Sent: 16 January 2021 13:48:37
To: Planning Reps
Cc:
Subject: Re: Planning Application Consultation for application 20/01514/FUL at Wilmington Hall Farm

From: planning.reps@dartford.gov.uk
Sent: 12 January 2021 12:36
To: clerk-wpc@outlook.com
Subject: Planning Application Consultation for application 20/01514/FUL at Wilmington Hall Farm

00 Block Plan

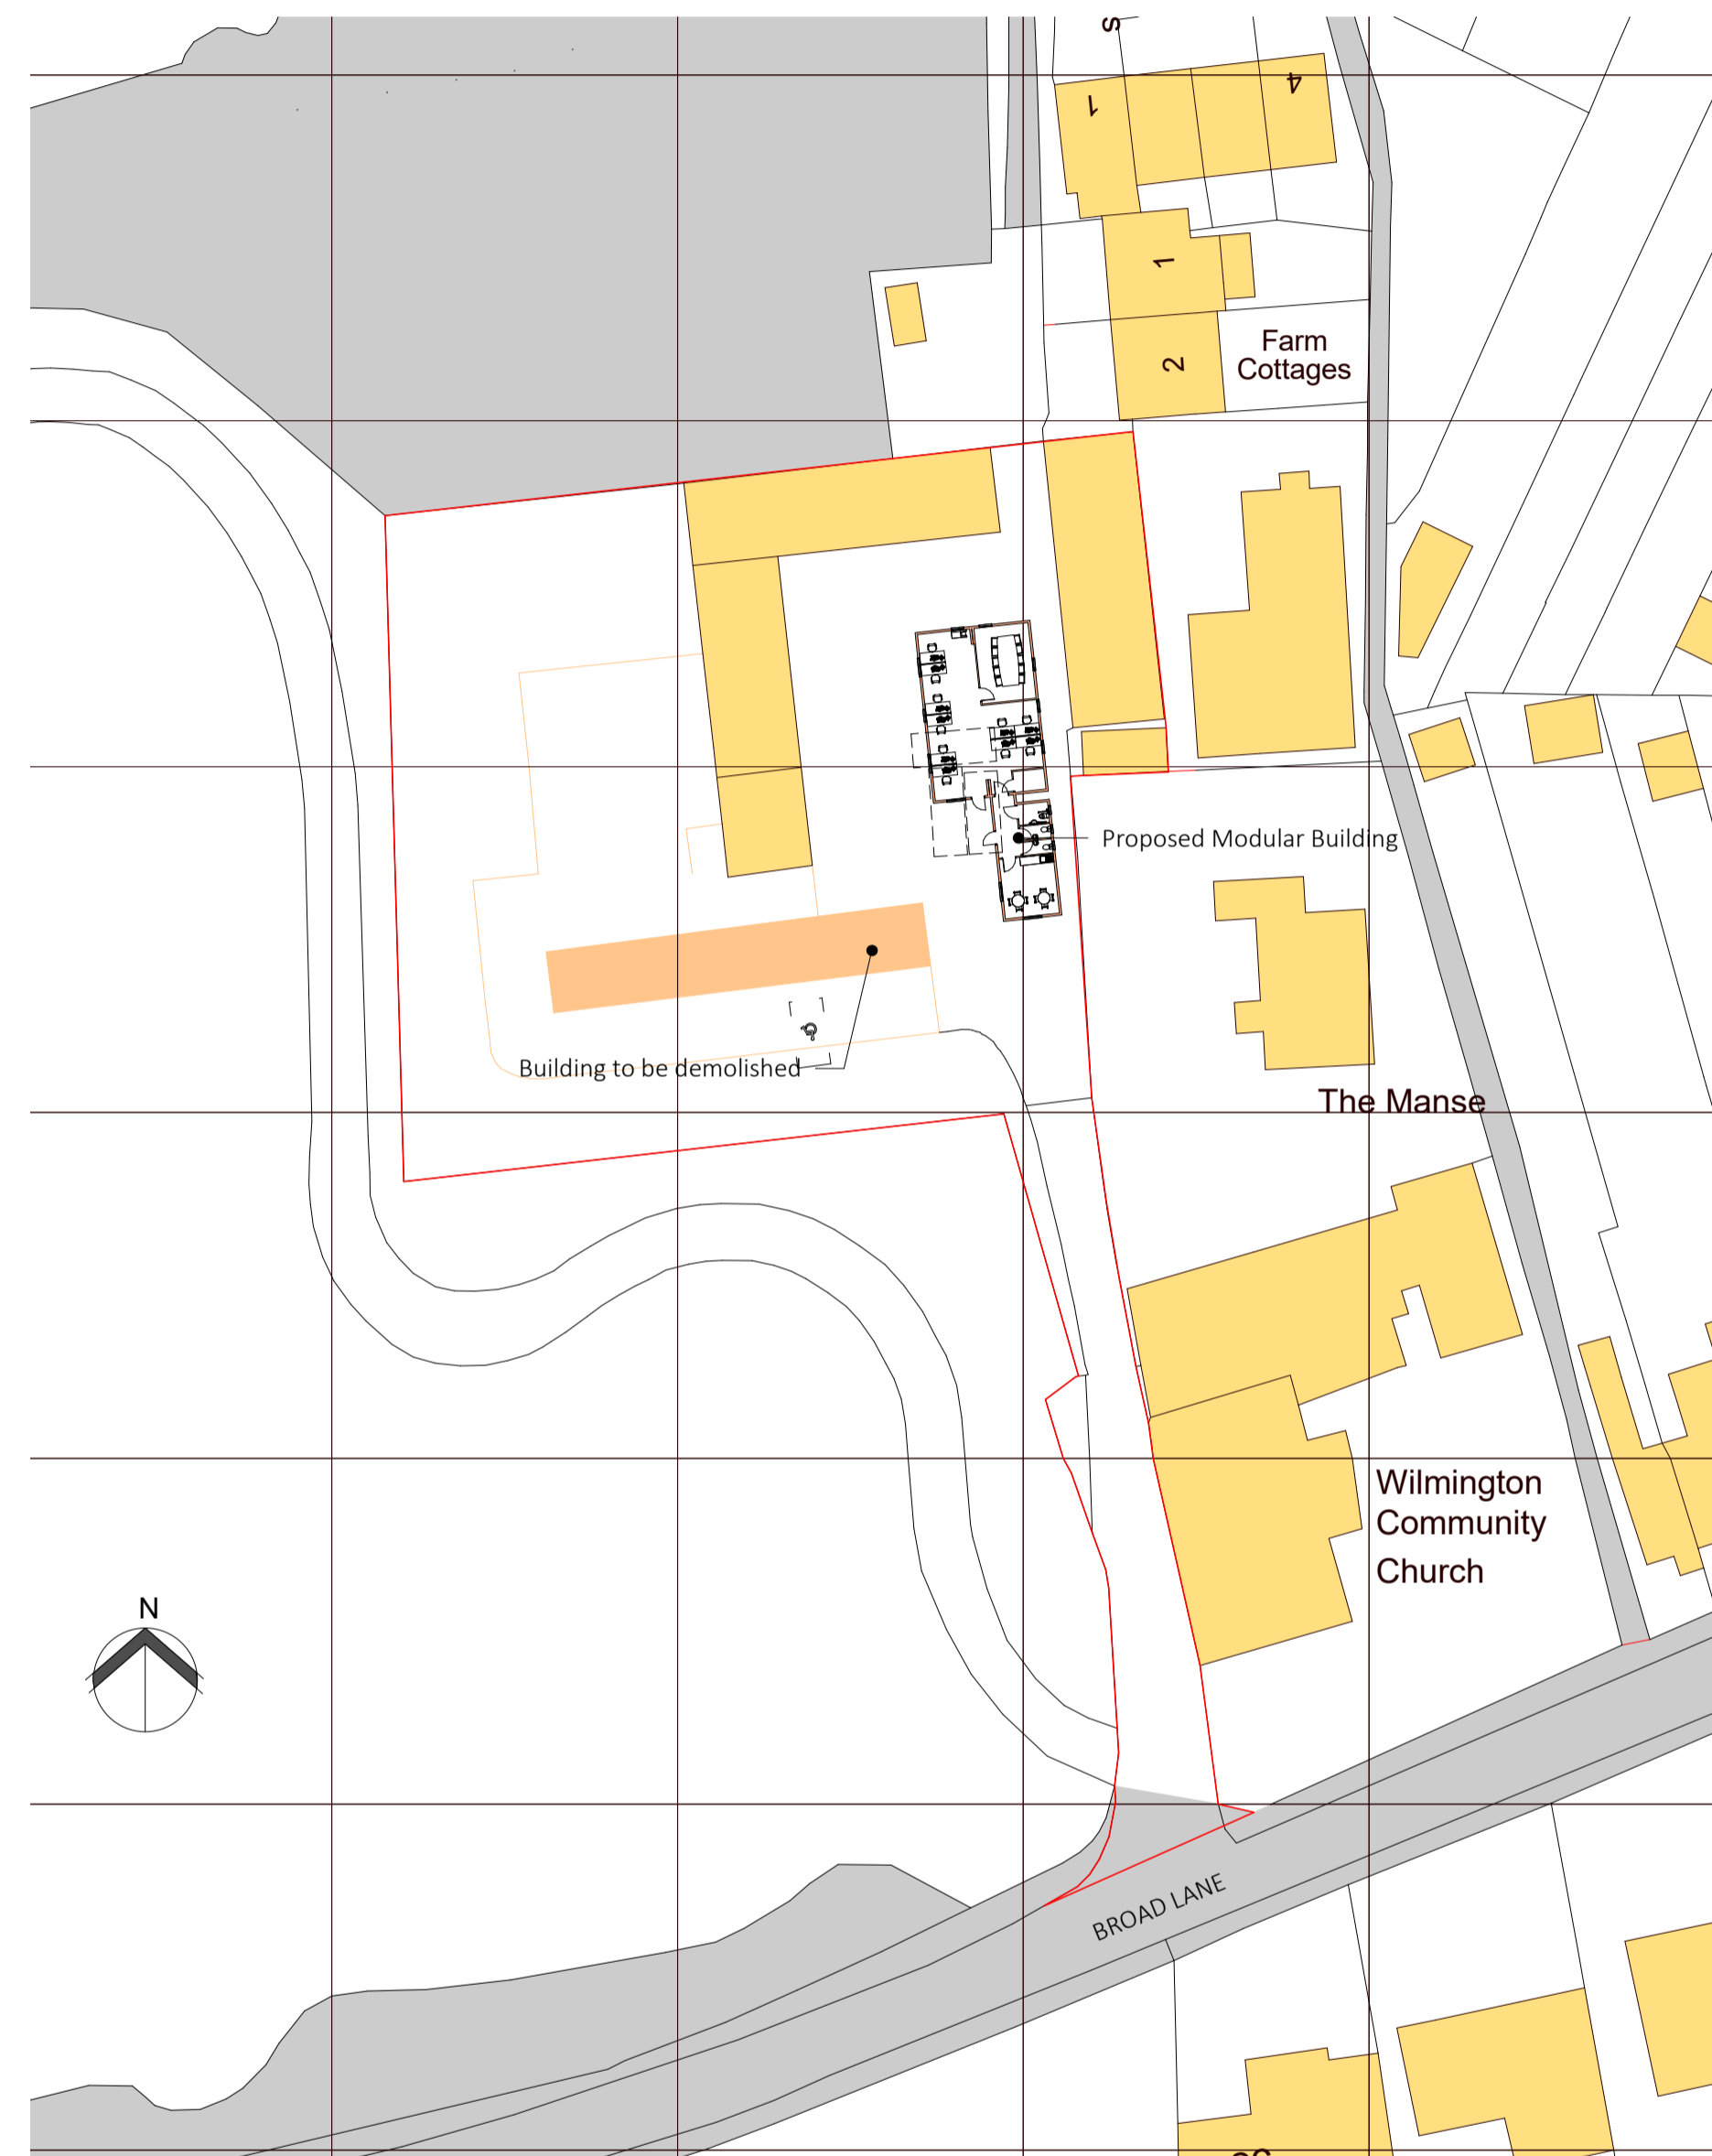
The Parish Council objects to this application due to inadequate access to the site, the increased traffic congestion along Broad lane and possibly use of the restricted width Hook Green Lane as an alternative route to/from the site
The proposed site layout does not include swept path analysis for the entrance onto Broad Lane. It is the Council's opinion that there is insufficient space on Broad Lane for ingress and egress for rigid 4 axle vehicles up to the maximum permitted 12 m, nor for articulated vehicles of up to 16m, both of which are likely to be used for a business of this type.
Recognising the bend and vegetation on Broad Lane to the west of the entrance, the visibility splays appear to be insufficient to allow safe large HGV egress, see attached Google Photos
The narrowness of Broad Lane with numerous pinch points does not afford a suitable access for regular large HGV access to the site.

Client: **Roger Bullivant Ltd**  
Project: **Proposed Depot**  
**Broad Lane, Wilmington**  
**Dartford, Kent DA2 7AQ**  
Drawing Title: **Proposed Modular Building**

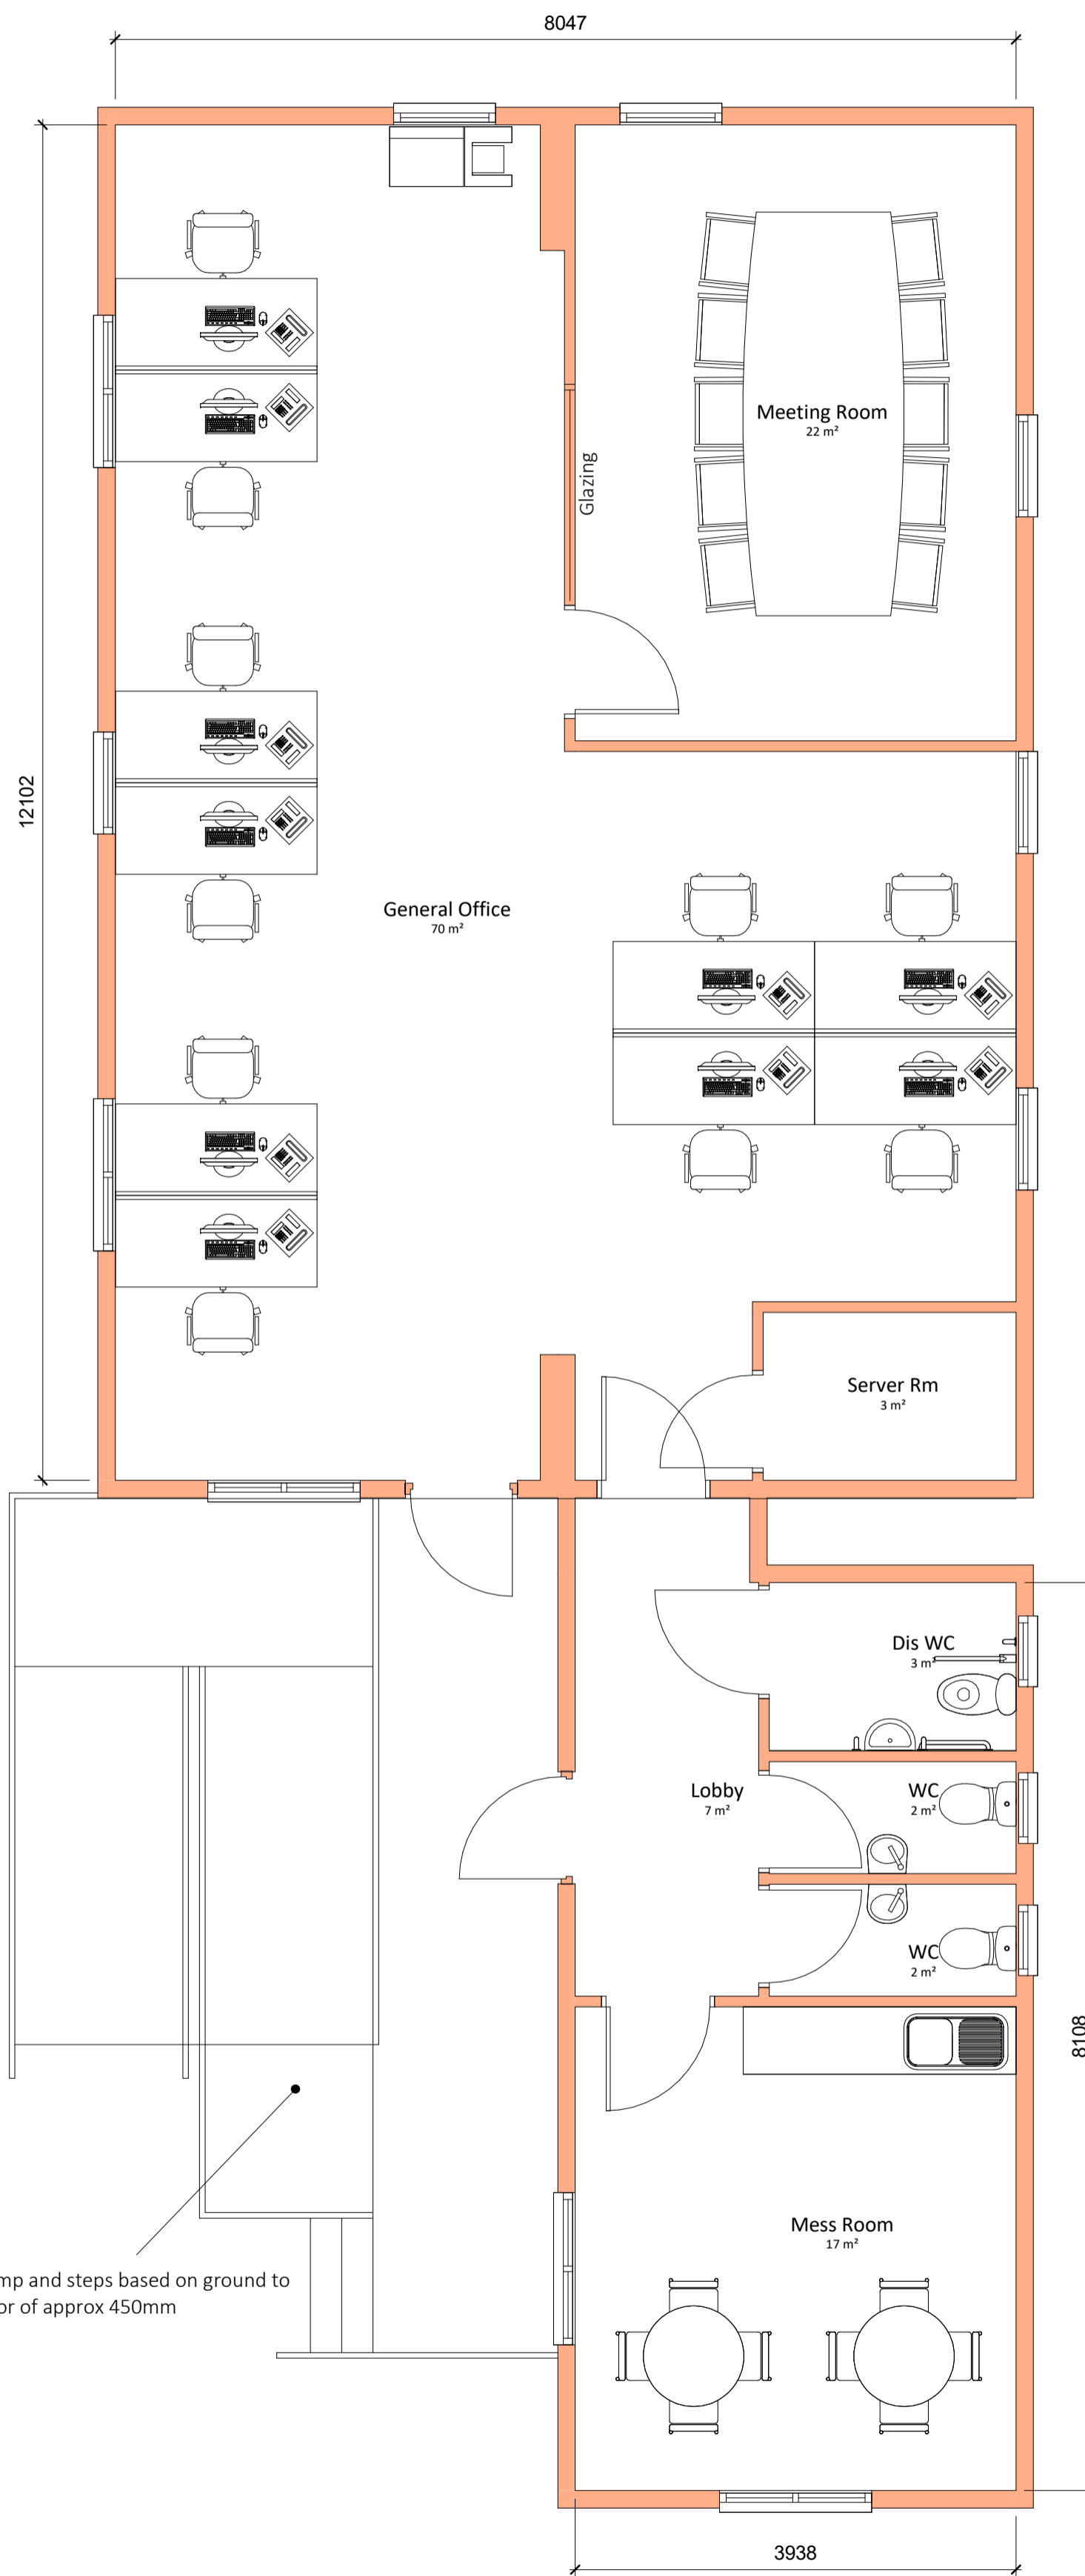
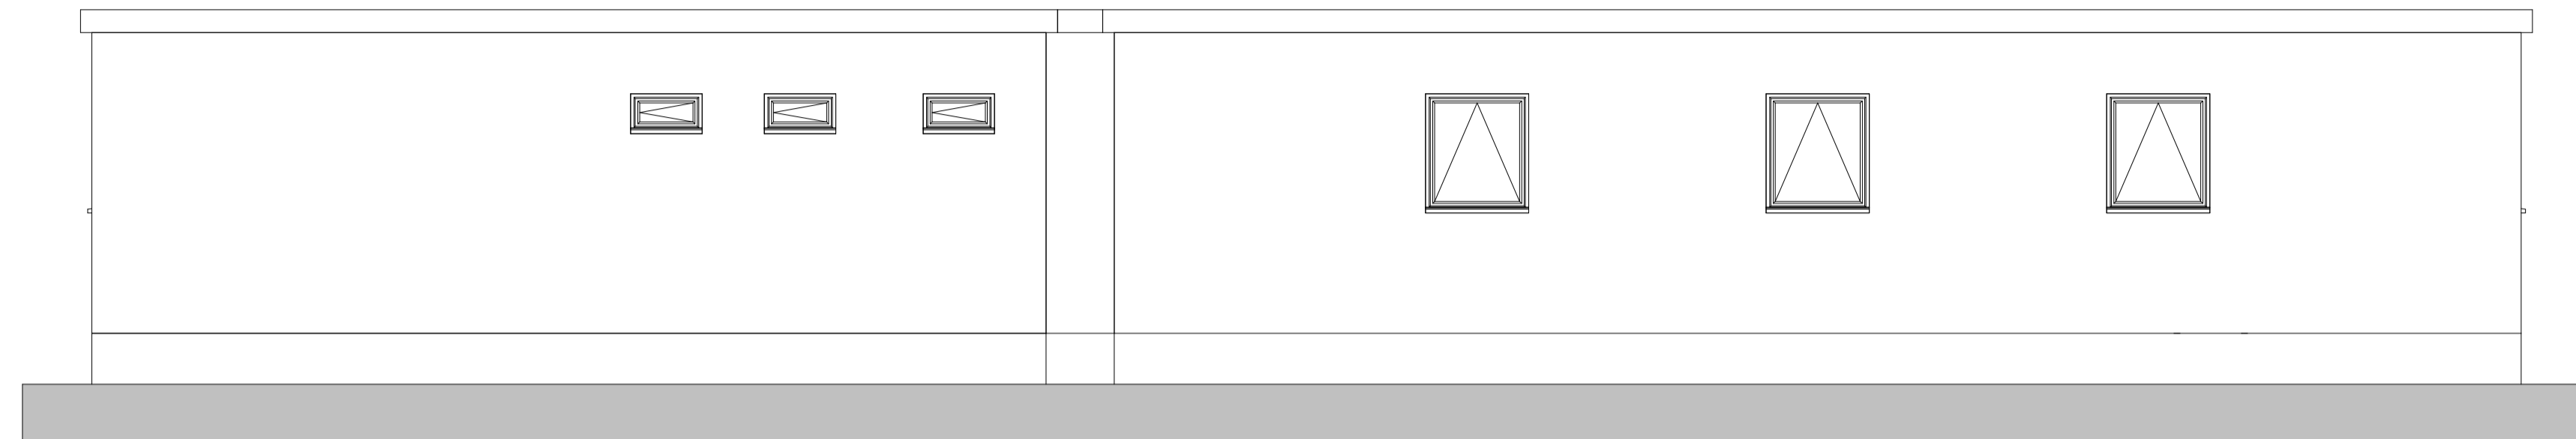
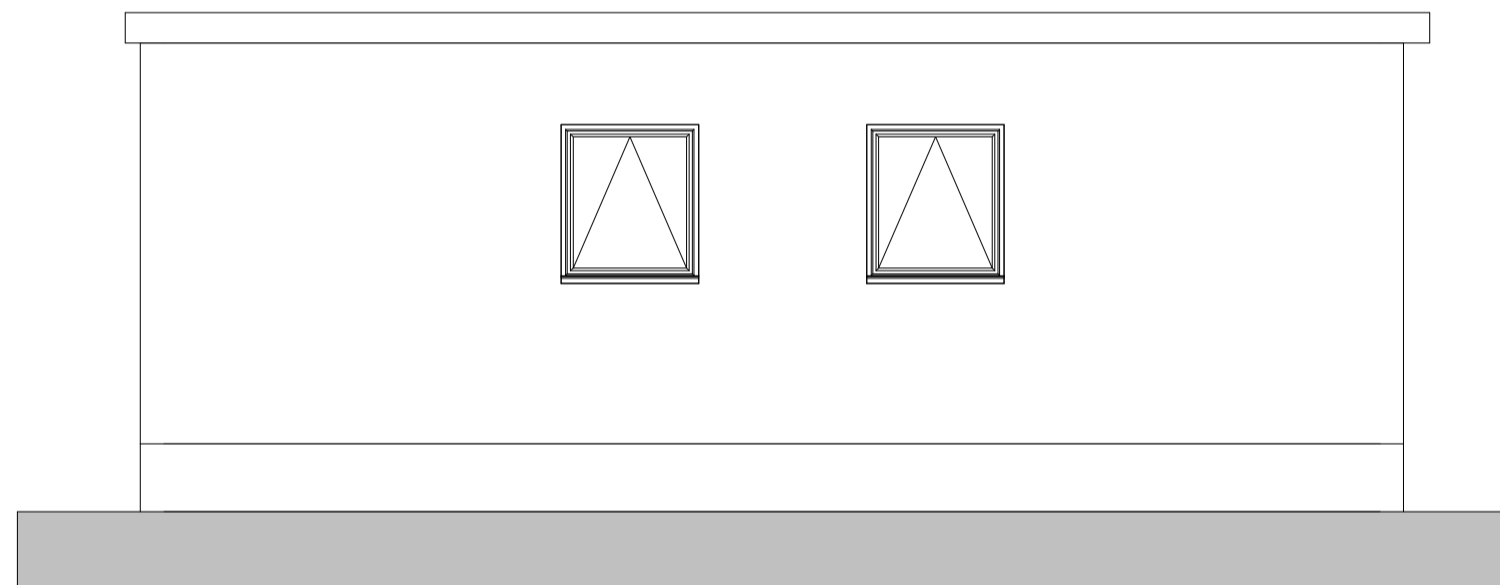
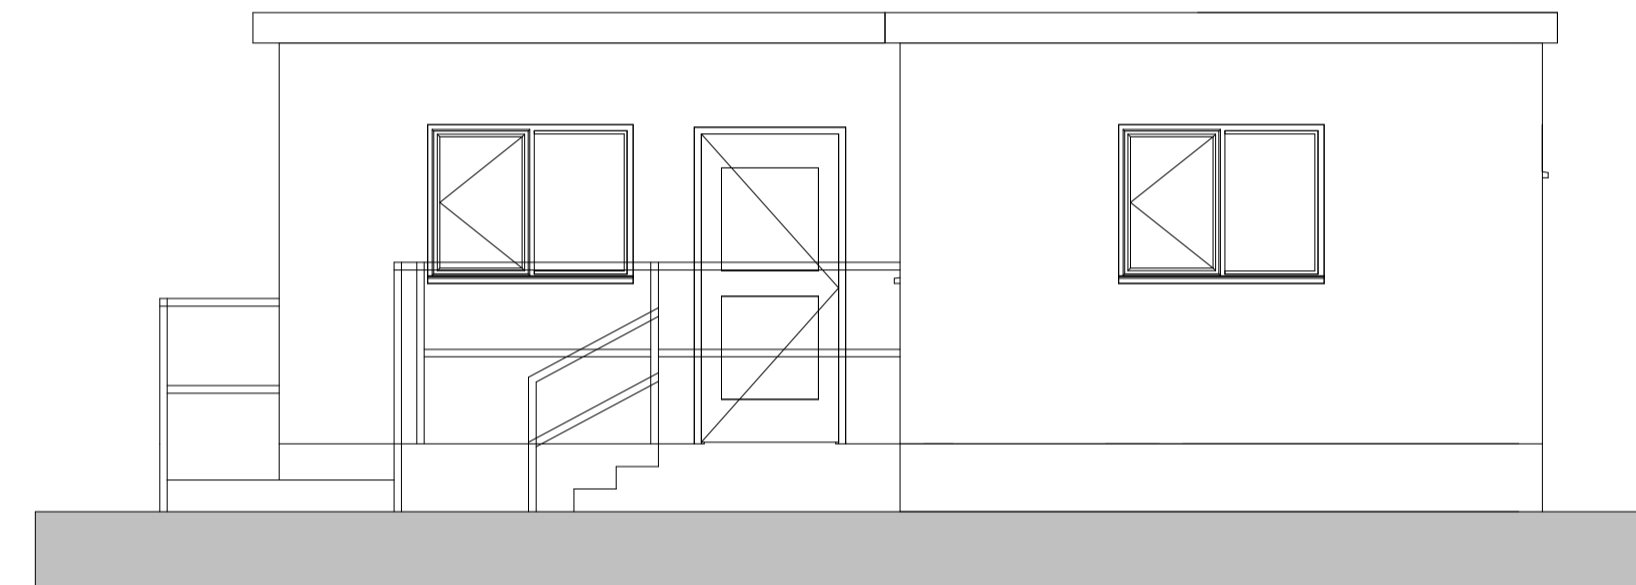
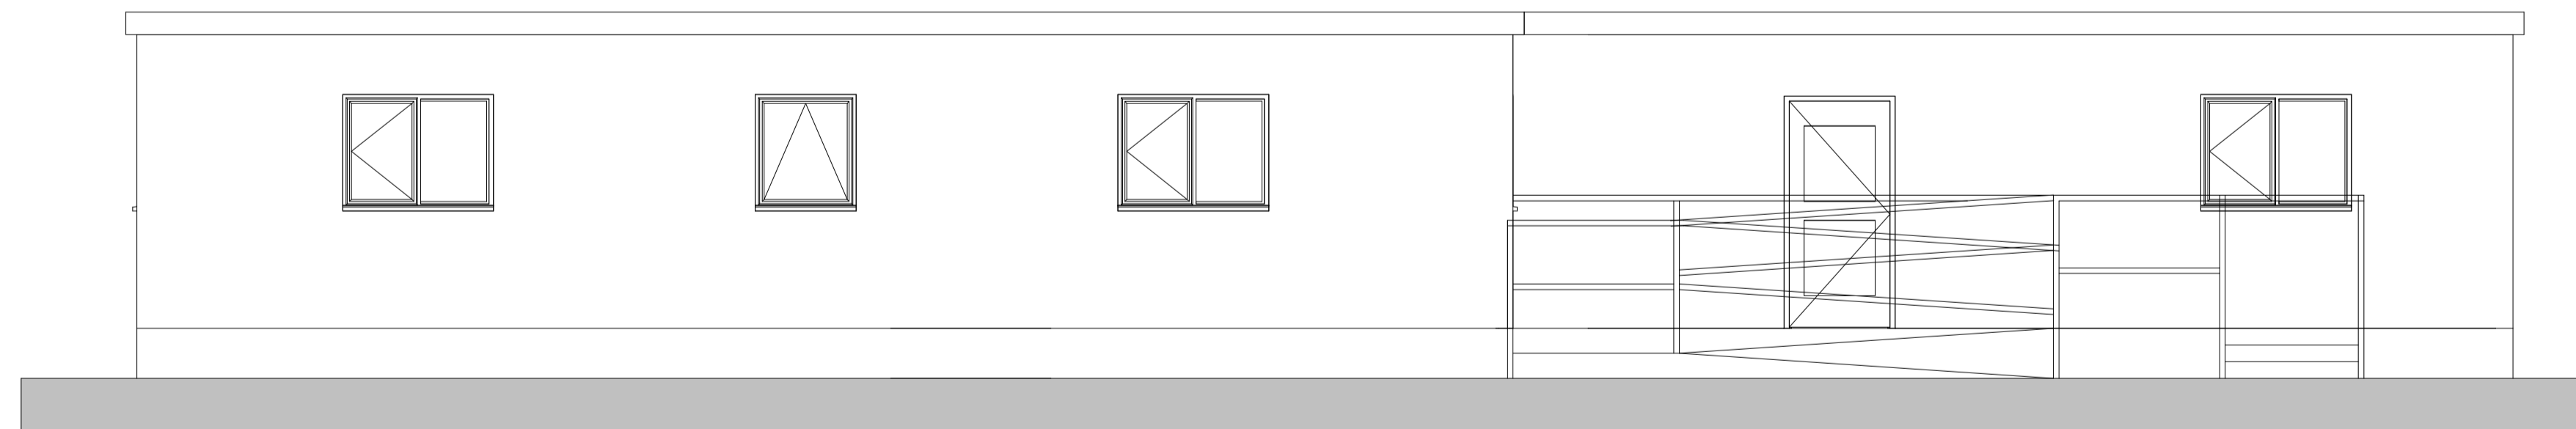
The additional traffic generated will exacerbate traffic congestion and pollution in an area close to 4 schools, in particular at the junction with Common Lane and will increase traffic dangers expose the
The extent of the proposed office, 10 desks and 10 seated conference area appears to be in excess of the amount of office space required to service a simple storage area, hence may generate further traffic over and above that that may be generated by the simple storage use, and may not be consistent with approved use.
Given the nature of the equipment to be stored on apparently porous surfacing there is concern on possible surface soil contamination.
Given the possible height of the equipment to be stored on site there will be some adverse impact on the views from the adjacent Green Belt.
